SYLVAN MEADOWS FILING NO. 2A

A REPLAT OF LOT 27, SYLVAN MEADOWS FILING NO. 2

EL PASO COUNTY, COLORADO

County File No: VR205
7-2-20 1 of 2

# SYLVAN MEADOWS FILING NO. 2A

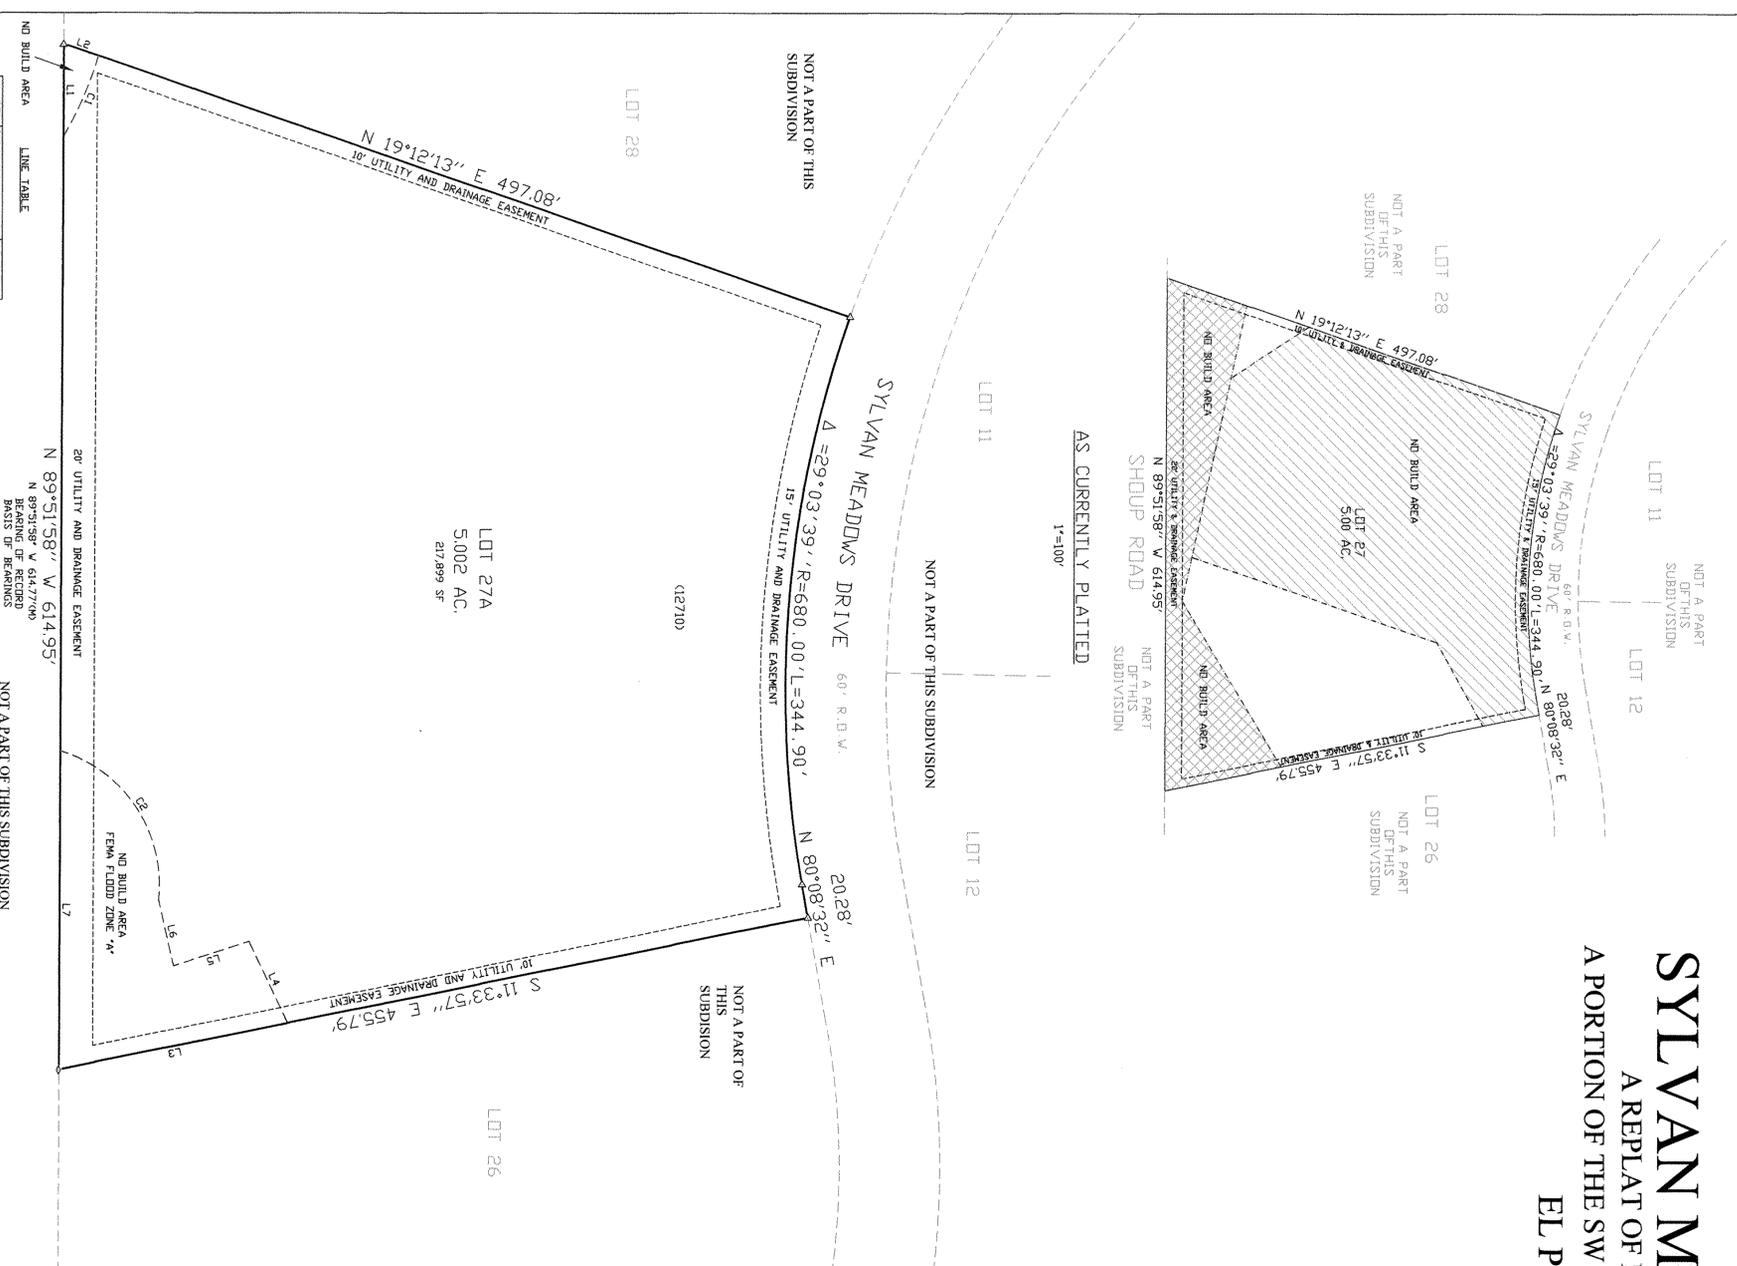
See additional comment regarding ratification of plat. Either include ratification statement with recording or include mortgage company as an owner signatory to this plat.

Per previous comment, please also include a note that lots 11, 12, 26, and 28 are not included in this plat. You have only included this note on the above current plat.
